DECISION DELEGATED TO HEAD OF PLANNING

Application No: H09-0627-25 **Applicant:** Mr H Juniper

Proposal: Proposed extension to dwelling to form bedroom and en suite above former garage

Location: 28 Balmoral Way Holbeach Spalding

Drawing Title:
**Plans, elevation & section as
proposed**

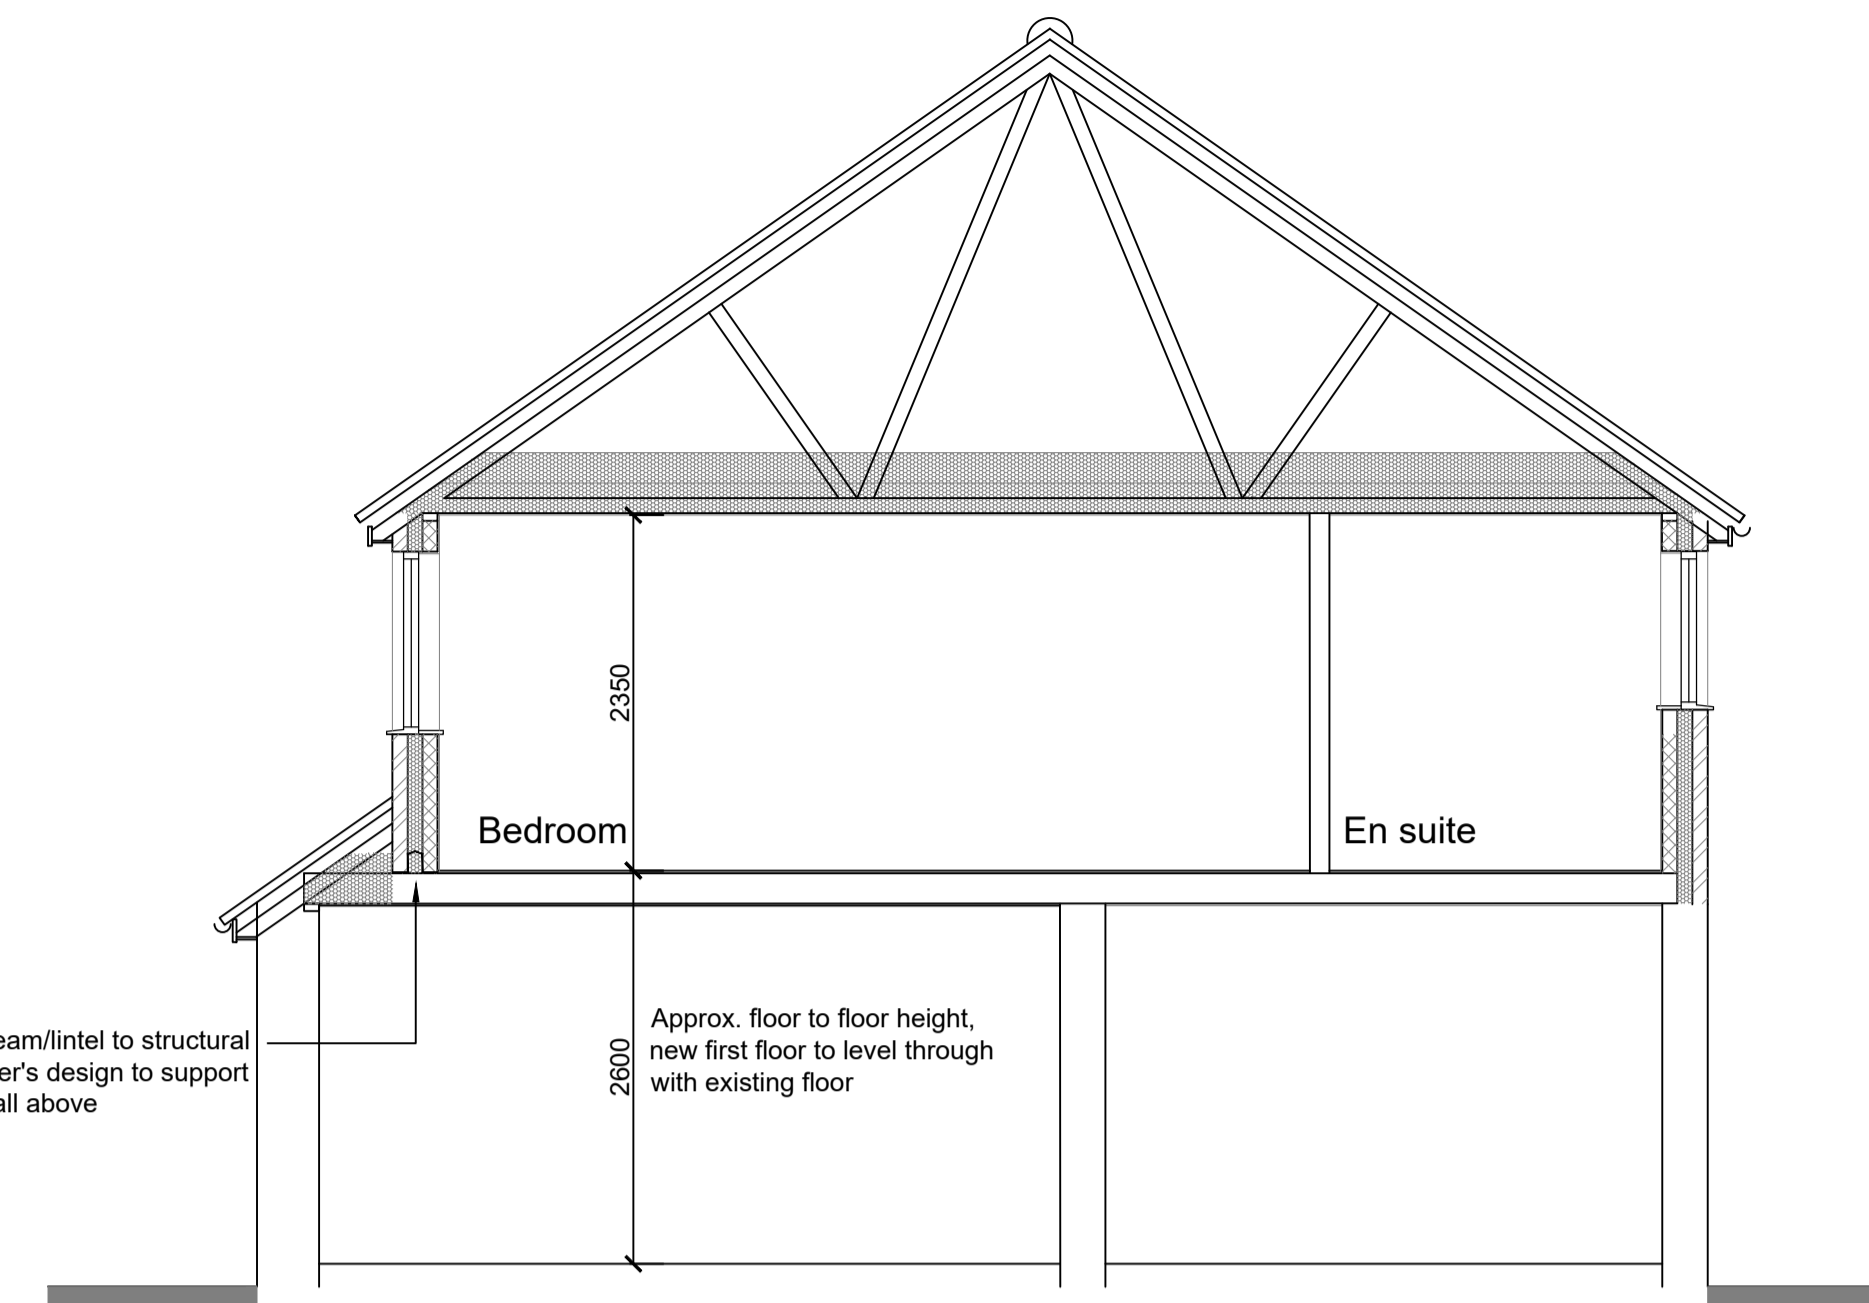
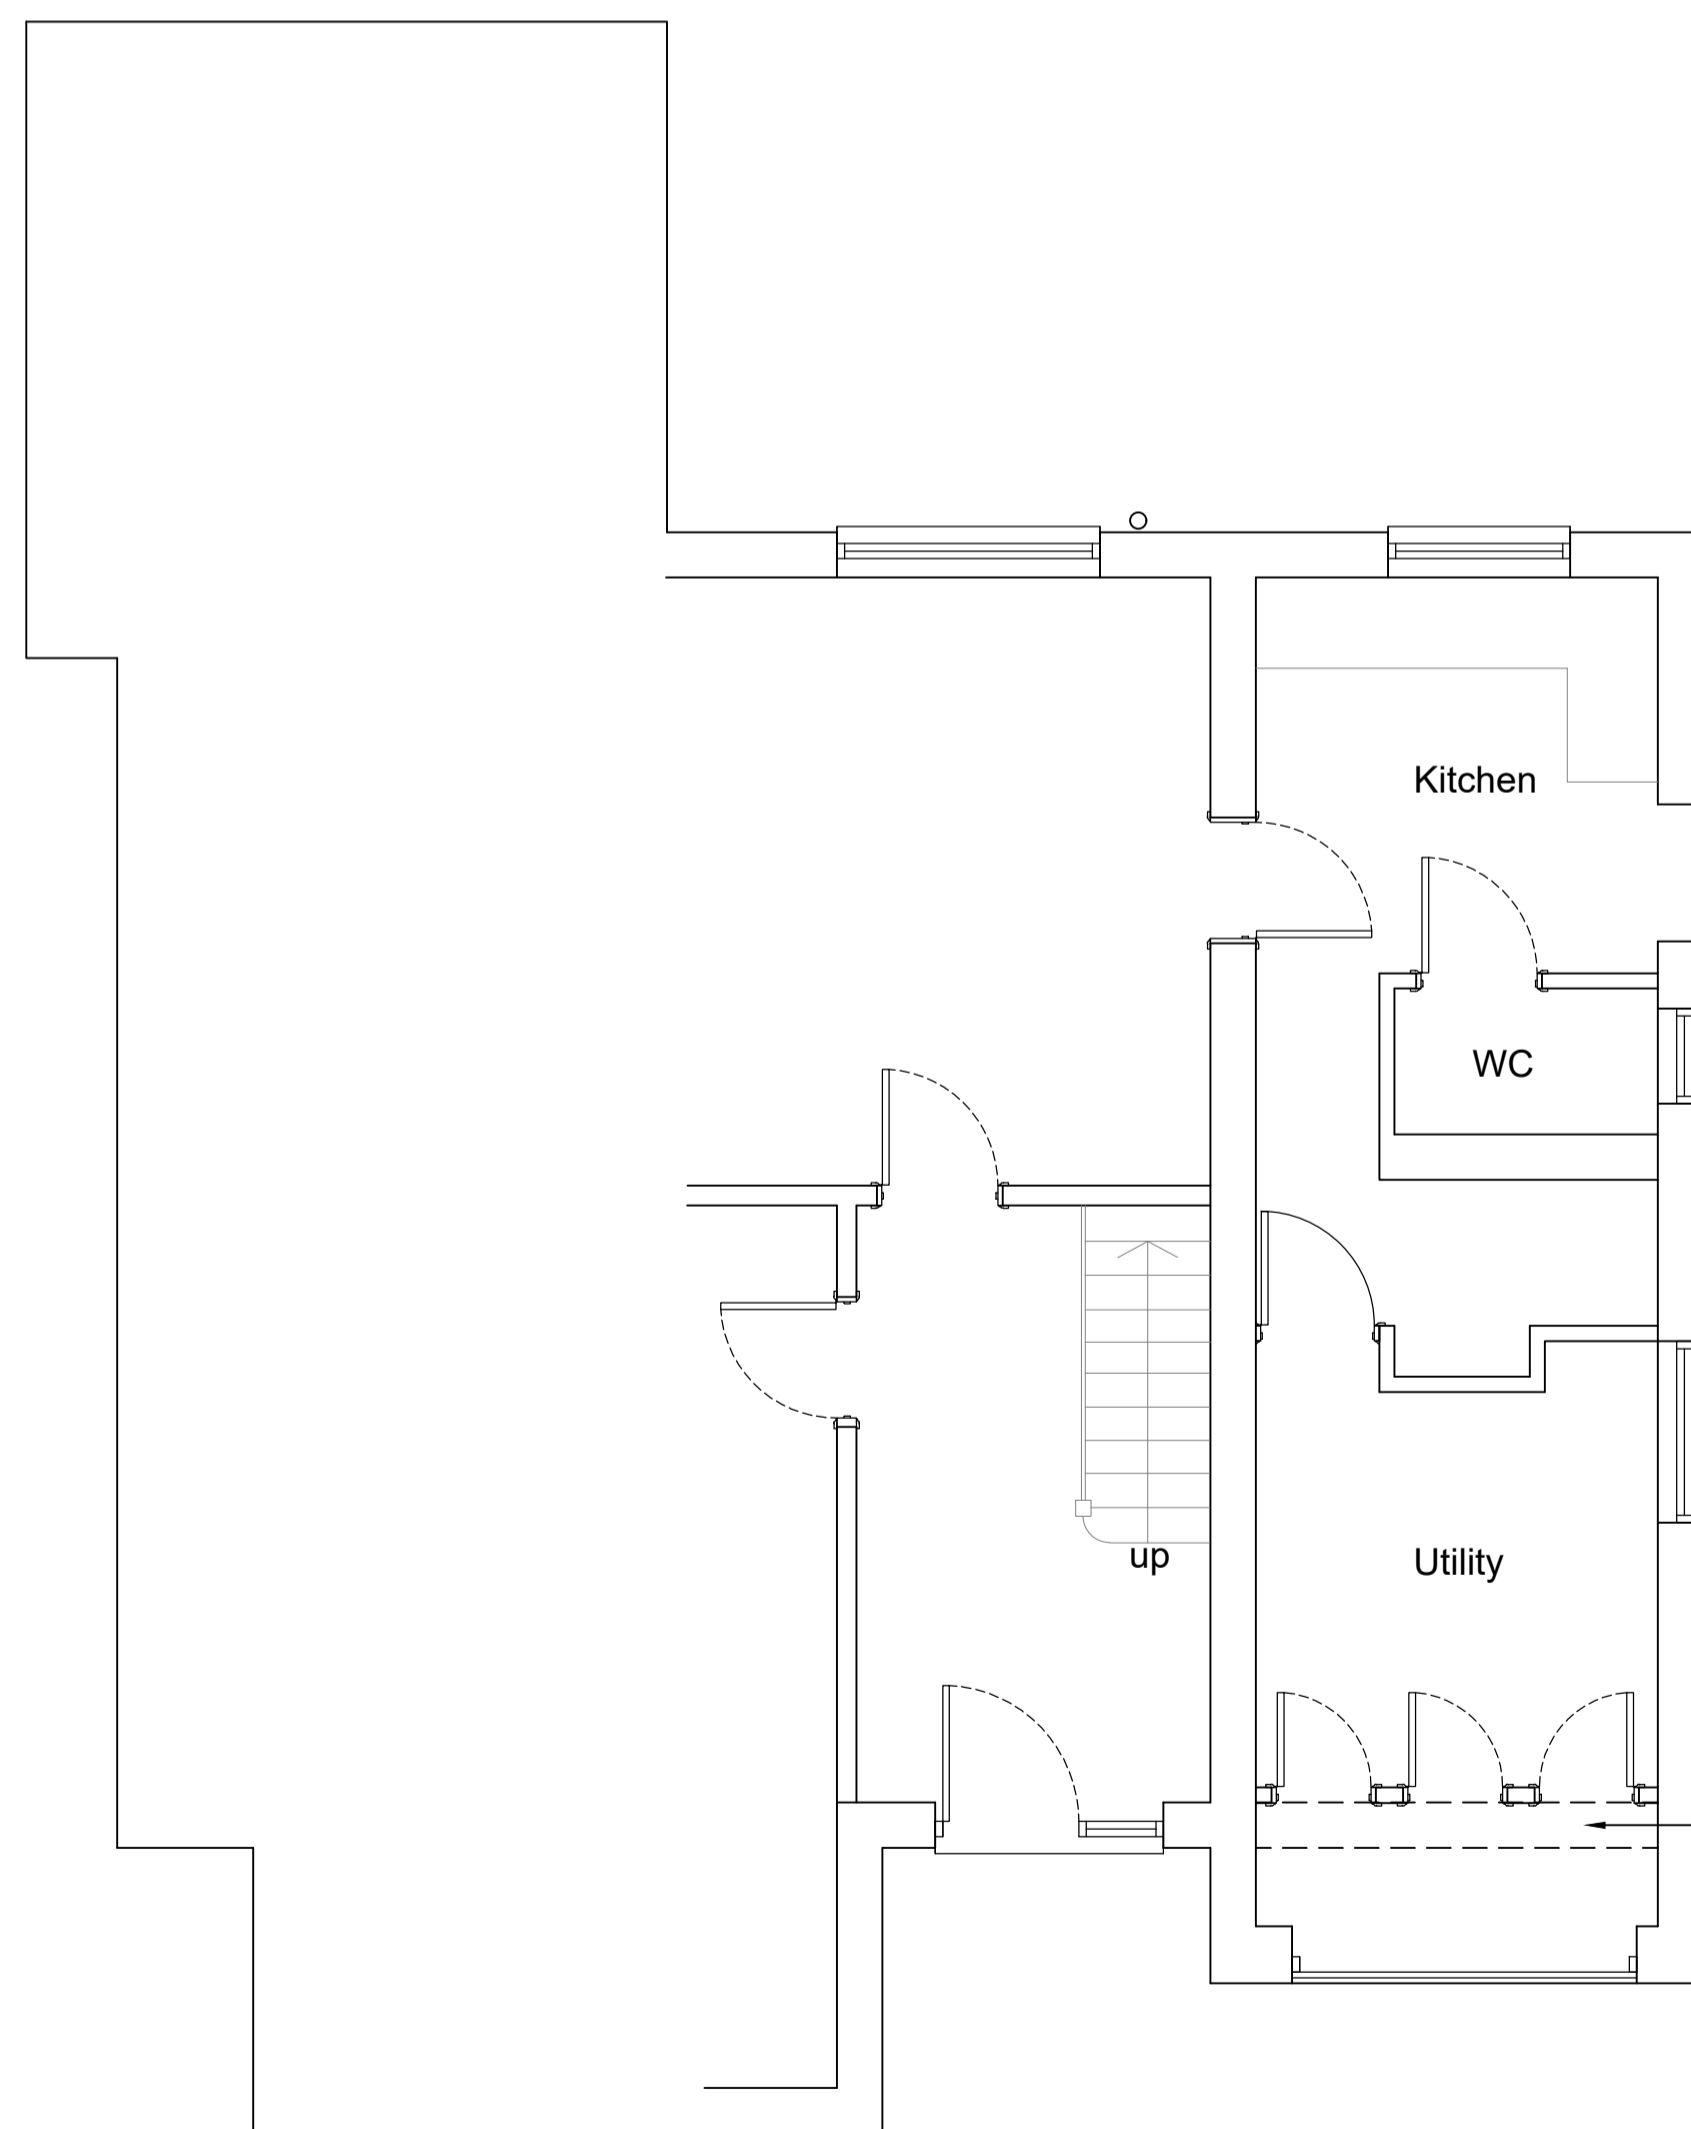
The extension would be constructed from existing materials throughout and would match the host dwelling. The extension would protrude from the side by 2900mm and would run the entire length of the main house, sitting at 8700mm. It would be level to the eaves and ridge of the host dwelling; being 5000mm and 8400mm respectively.

The proposed extension would project to the side of the host dwelling at first floor level, providing an additional bedroom and en-suite. The extension would project above the existing ground floor accommodation, which serves as a garage. The proposed extension would therefore sit on the same floor area as the ground floor section.

As the materials would also match throughout, this would ensure that the extension would remain in keeping and thus acceptable in this regard. Whilst the extension is not subservient, given that it would be level to the ridge height of the existing dwelling, this is not considered to be a significant enough issue to warrant a refusal.

The window proposed to the front, serving the proposed additional bedroom, would be acceptable in this instance. Despite facing other existing dwellings, it would be not form a notably different outlook in terms of impact, to that of the other windows across this elevation. In a similar light, the window to the rear would be obscure glazed due to it being for an en-suite. This would be conditioned to ensure that it remains this way and that there is no impact to the amenity of residents through overlooking.

Due to the positioning of the site, this ensures that the only shadow that could be cast would be to the direct neighbour for No. 28. However, this would be at the latest point in the day when the sun is setting. Notwithstanding this, as the extension would be to the same height as the host property, there would be no significant increase in detrimental harm. As such, no overshadowing impact is considered to be raised.

Whilst the floor plan does not show the whole property, it can be assumed from the size of the dwelling that there would be at least three dwellings on the first floor. The side extension seeks to create an additional bedroom and therefore takes the number up to four. As a result, there must be at least three vehicle parking spaces to accommodate this and meet the standards set out in Appendix 6. The driveway to the front of the site could support up to three vehicles and whilst a garage door is featured on the front elevation it should be noted that this has already been converted. Therefore, it accords to Appendix 6 and provides enough vehicle parking.
